DELEGATED DECISION TO DETERMINE PLANNING APPLICATIONS

Reference No:	2026/62/91303/E
Site Address:	30, Knowl Road, Mirfield, WF14 8DJ
Description:	Erection of detached garage
Recommending Officer:	Nicole Helliwell

Officer Report

Proposed Site Plan
1 : 500

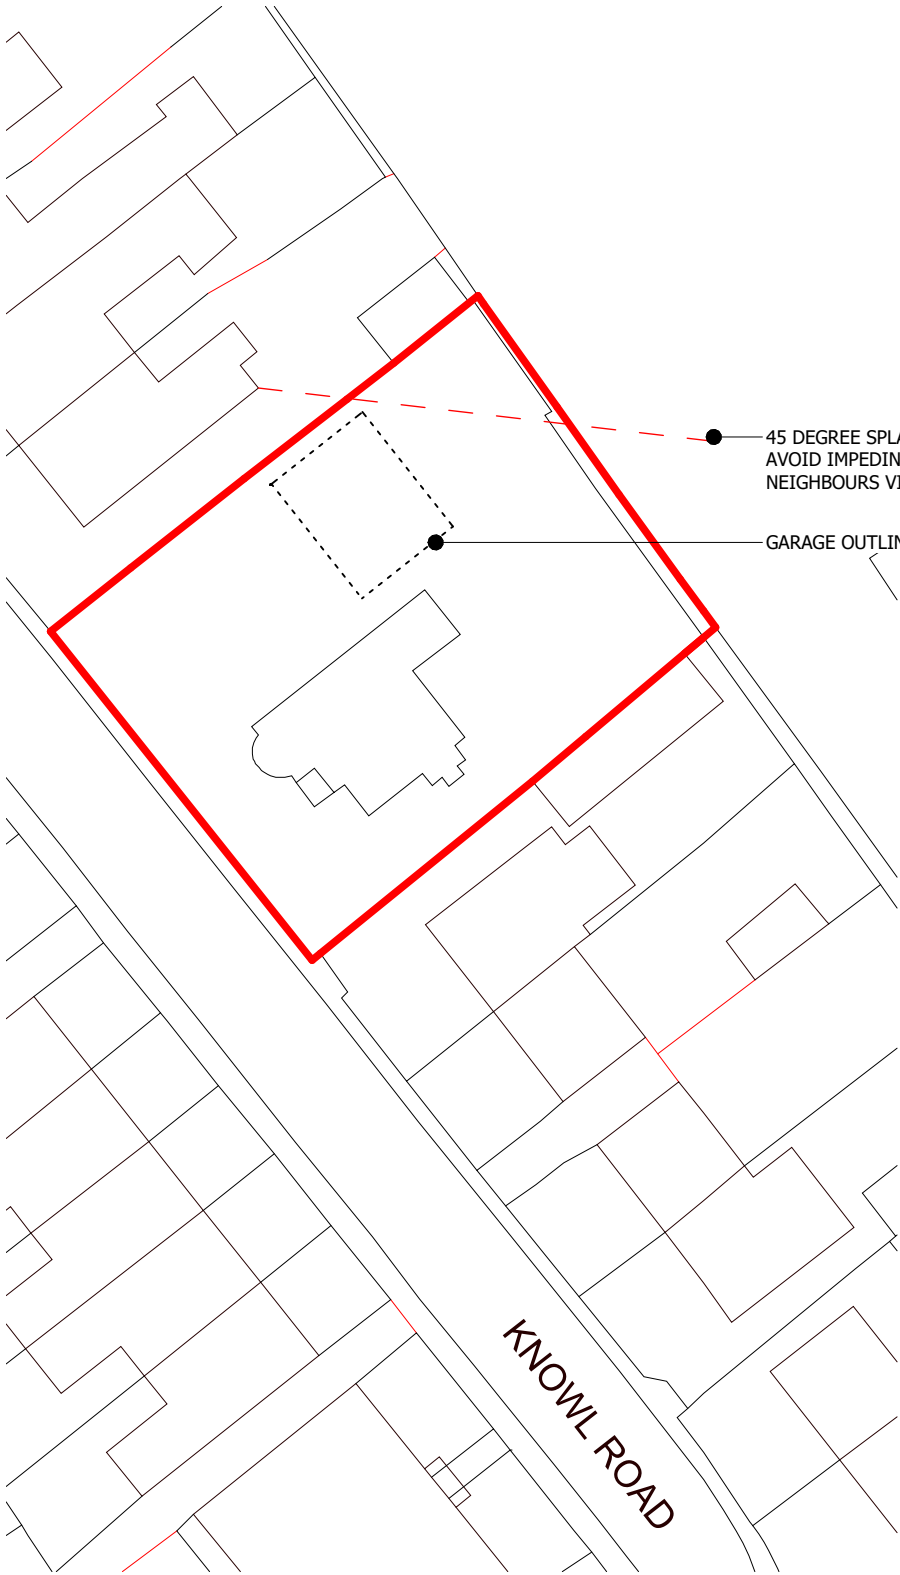
- The proposed garage is positioned in close proximity to the shared boundary with No. 32 Knowl Road. Based on the submitted site plan, the separation distance between the proposed structure and the side elevation of No. 32 appears to be approximately 5–6 metres. We feel that this distance is insufficient given the scale, massing, and siting of the proposed building.

- In this case, the proposed separation of approximately 5–6 metres appears materially below what may ordinarily be considered acceptable, particularly given the scale of the proposed garage and the sensitivity of the affected kitchen window.

- We do not object in principle to our neighbours constructing a garage; but prior to this would request that amendments are made to increase the

separation distance from the boundary and reduce the overall height of the structure. There is also ambiguity about its proposed position.

32 Knowl Road is a terraced property located to the north-west and occupies an elevated position relative to the application site. The proposed garage would occupy a position approximately 5.5m from the side elevation of no.32. Whilst the structure would surpass the rear elevation of the neighbouring dwelling, it would accord with the 45 degree rule in relation to the neighbour's rear fenestration. It is also noted that no.32 contains several windows within its side elevation, however, given the difference in ground level and that the structure is single storey in height, it is considered that there would be no significant detrimental impact on the neighbouring amenity as a result of the proposed development.

Officer Response: *The proposals potential impact to the neighbouring properties has been assessed within the 'Residential Amenity' section of the report.*

DRAWING TITLE
Proposed Garage

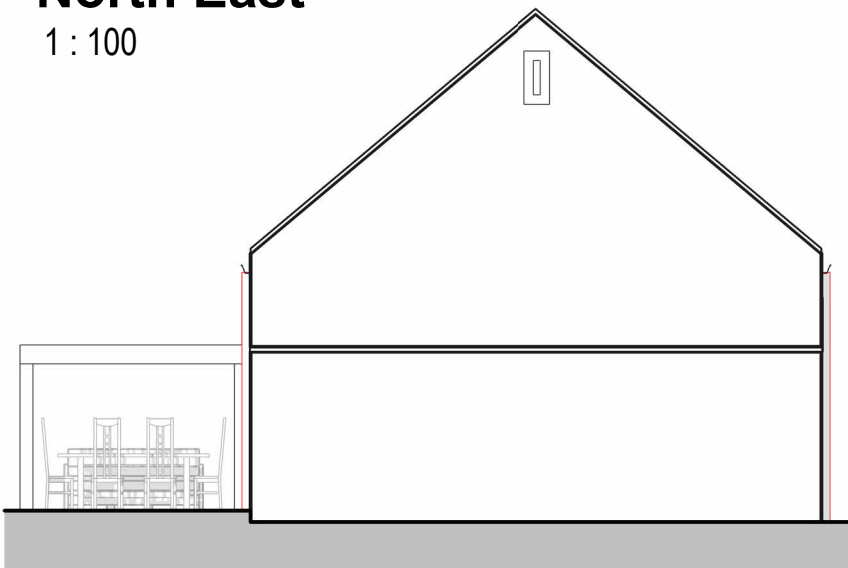
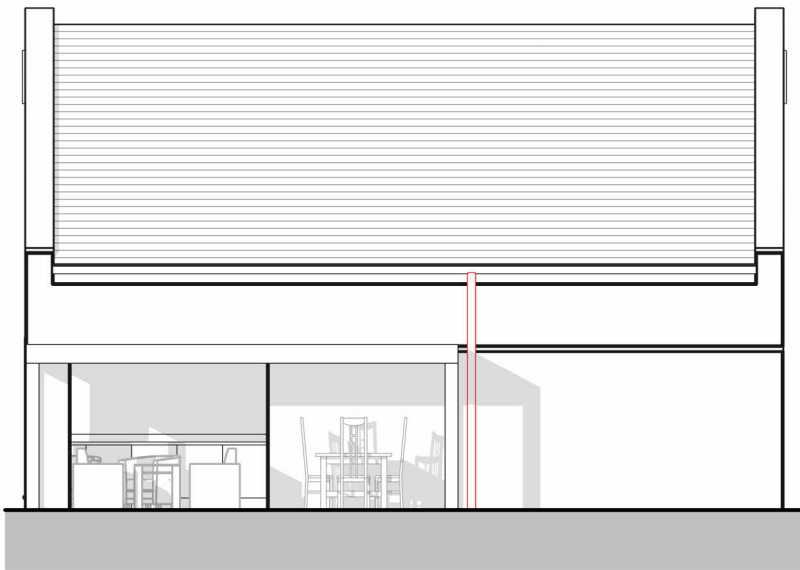
- The garage is not a minor structure but a substantial double garage with a significant roof form and ridge height, which would introduce a permanent and prominent built form adjacent to the neighbouring boundary. We are concerned that the proposed building may create an overbearing and enclosing effect when viewed from the garden of No. 32.

- No. 32 has a primary kitchen window located on the side elevation, which provides an important source of outlook and natural light to a principal habitable room. The submitted plans suggest that the garage would occupy a dominant position in close proximity to this window, reducing openness and outlook. The development would replace an otherwise open aspect with a substantial built form, potentially resulting in a noticeable reduction in visual amenity for the occupiers of No. 32.

The detached garage would be single storey in height and would be located north-west of the host dwelling. The structure would be 'L' shaped and would measure approx. 10m overall in width, approx. 7.56m overall in depth and approx. 6.8m overall in height. The garage would be constructed from natural stone for the external walls and would incorporate a dual-pitched roof finished in natural slate which would generally match the appearance of the original build. Although the proposed structure would have a large footprint and scale, it would appear subservient in relation to the host dwelling and would be set back approximately 17.35m from the public pavement which would reduce its prominence and visibility from vantage points along Knowl Road. For these
